Application no: H13-0218-11

Description: Proposed ground floor extension to dwelling

Location: Old Chapel
Mill Marsh Road
Moulton Seas End
Spalding Lincs
PE12 6LR
PE12 6LR

ACKNOWLEDGEMENT OF AMENDMENT

DRAWING PROPOSED ELEVATIONS 3D VIEWS AND BLOCK PLAN
JOB REF 2210/11 DRAWING NO 02A DATE MAR 2011 DRAWN JPW
SCALES 1/100 1/200 AND NO SCALES TO 3D VIEWS

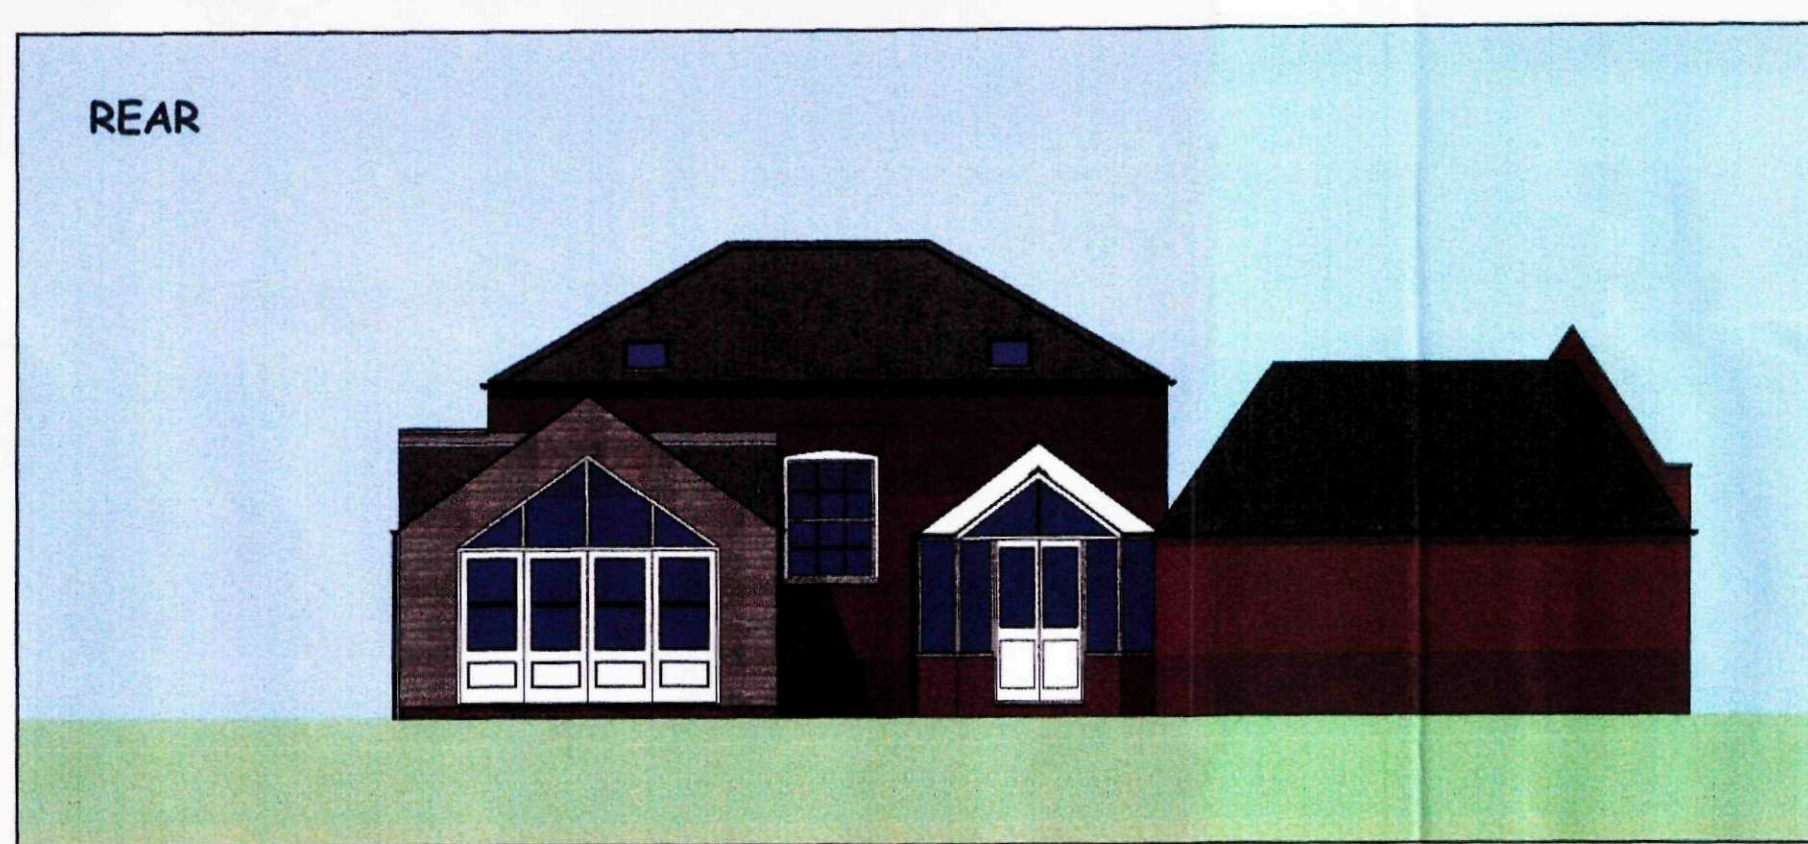
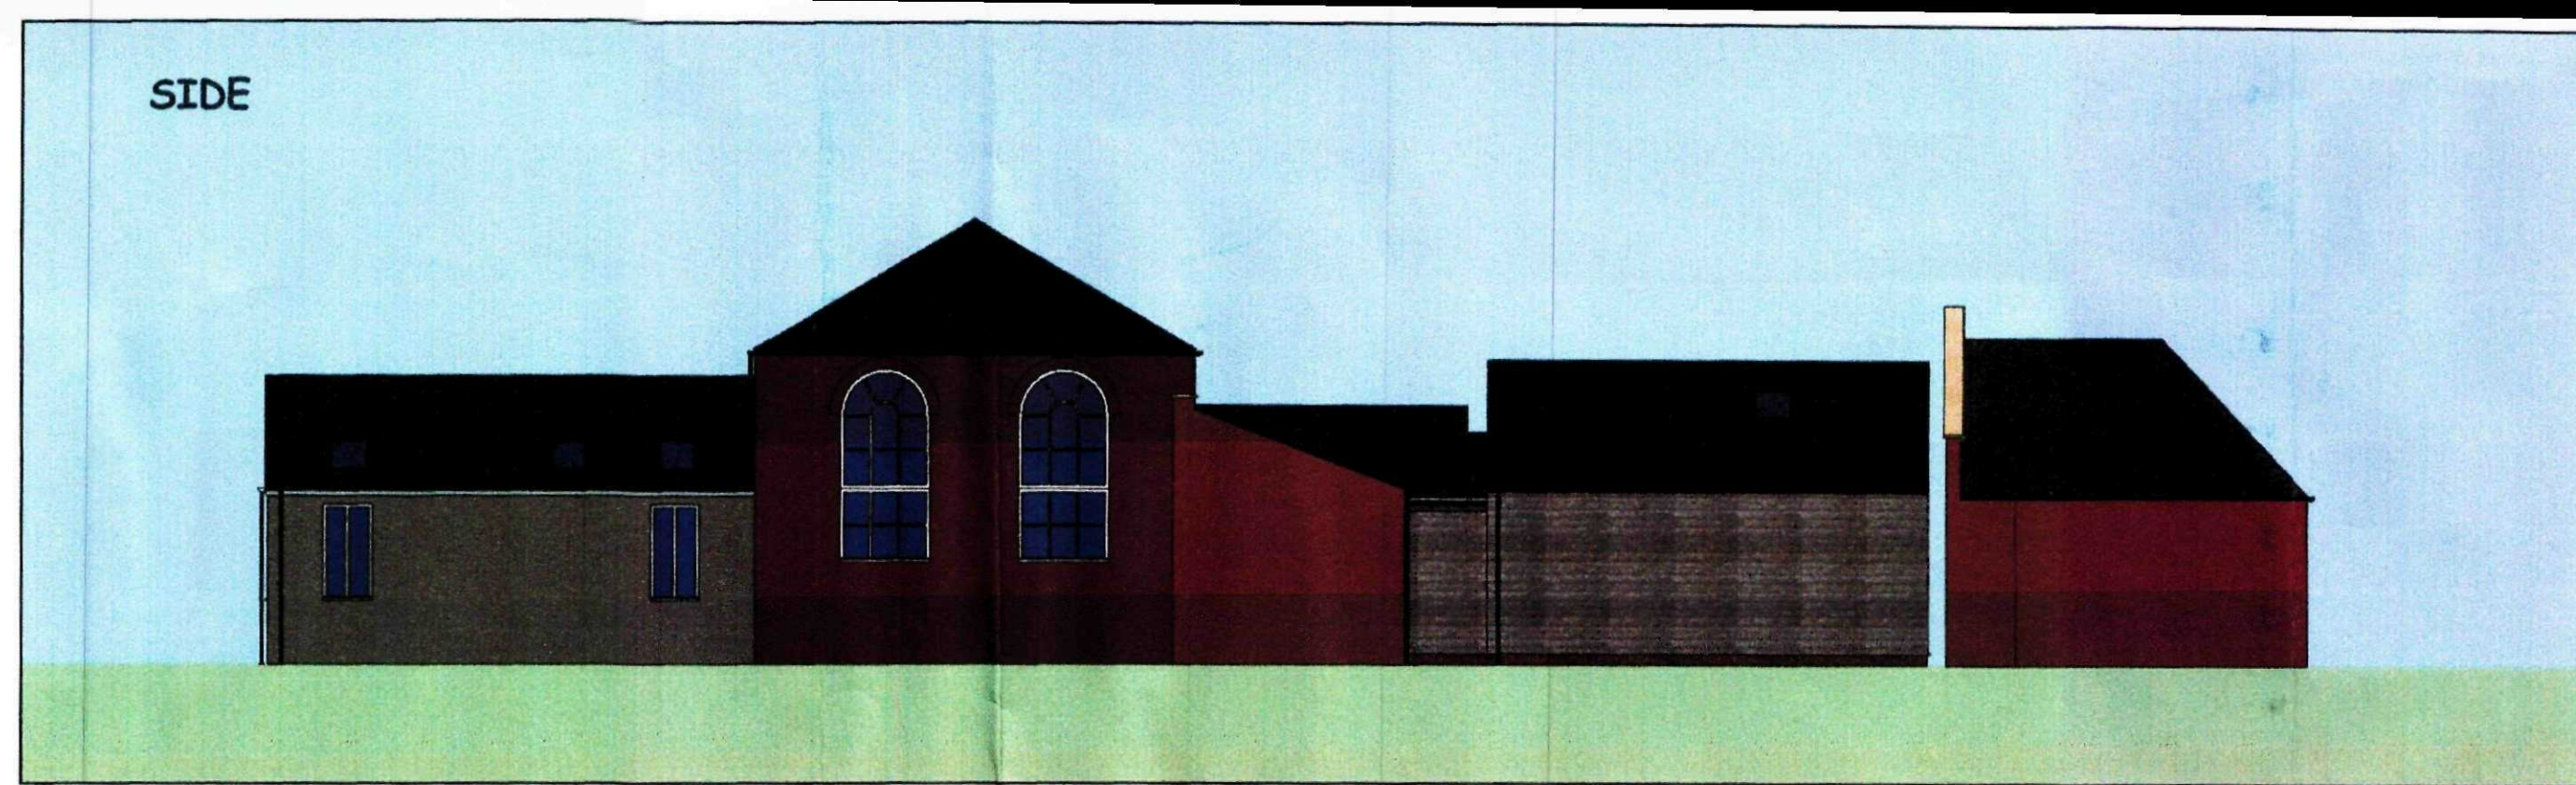
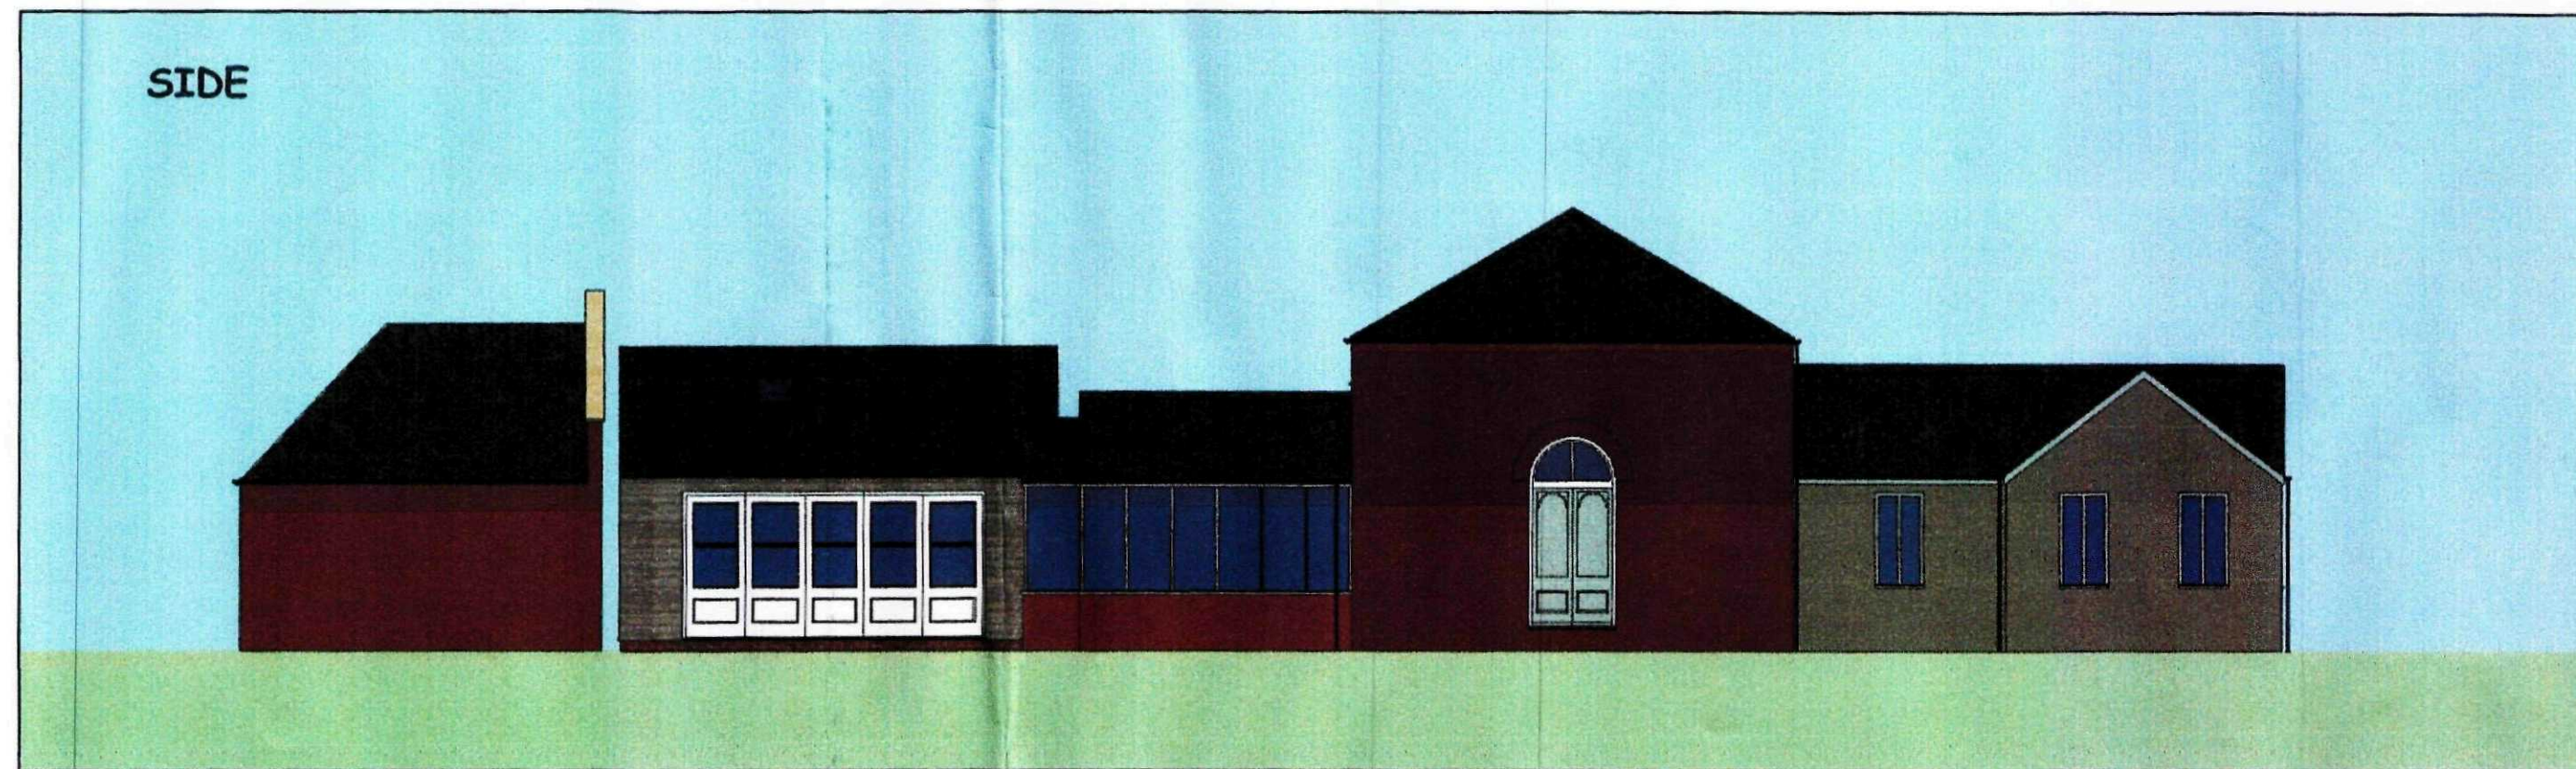
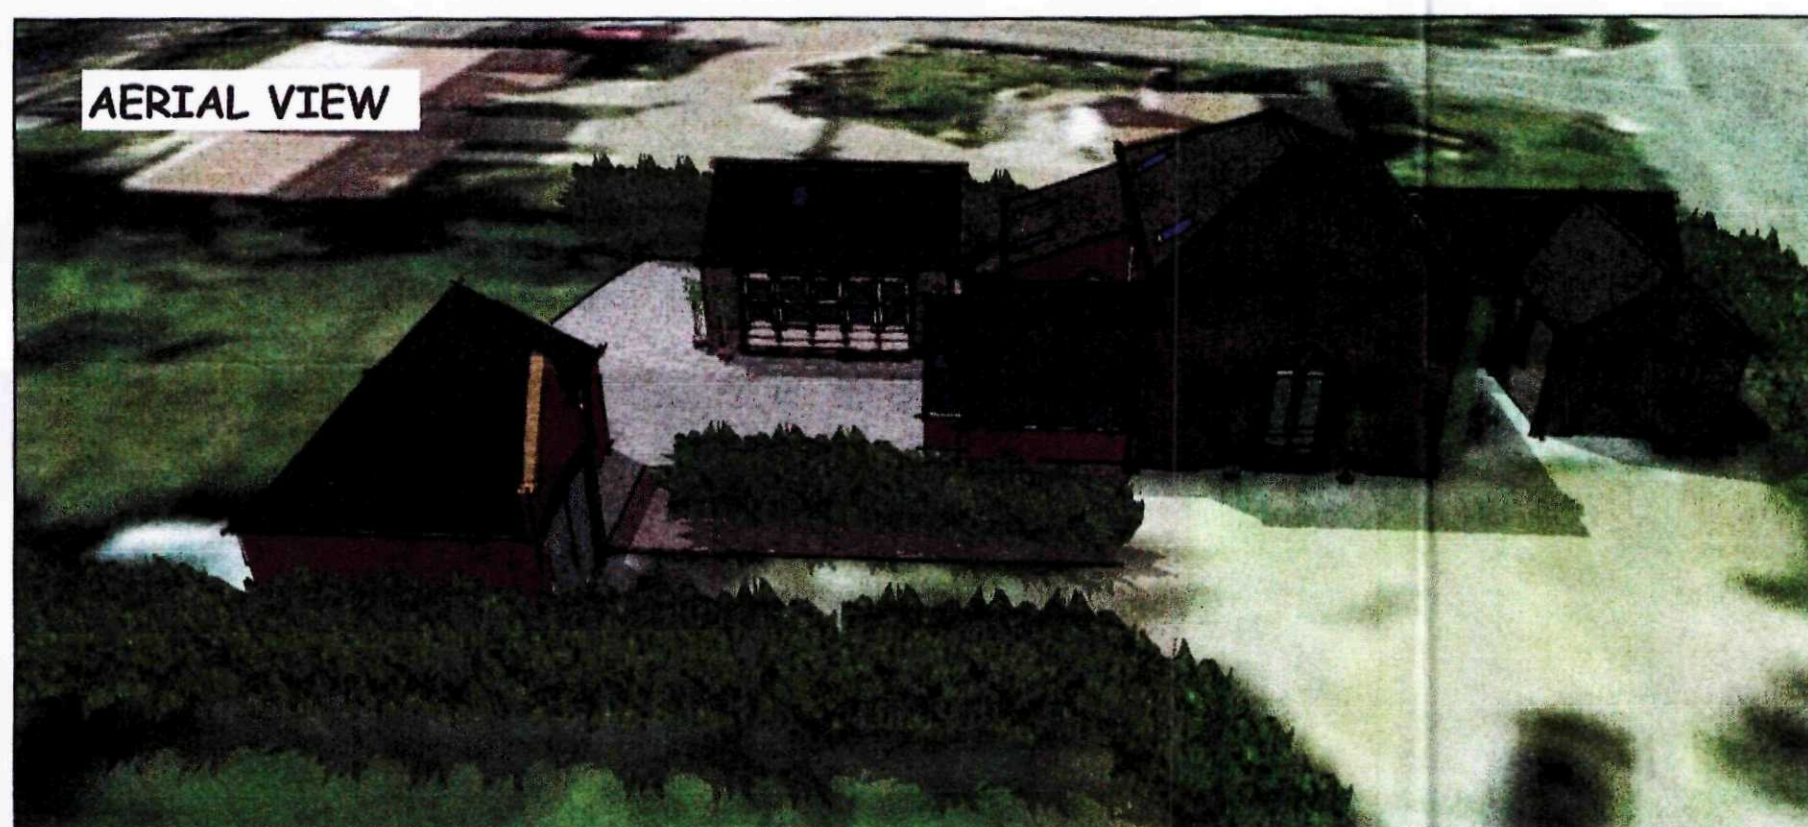
Amendment: Omitted box seat and flues (dwg. nos. 2210/11-01B,
2210/11-02A and 2210/11-03A)
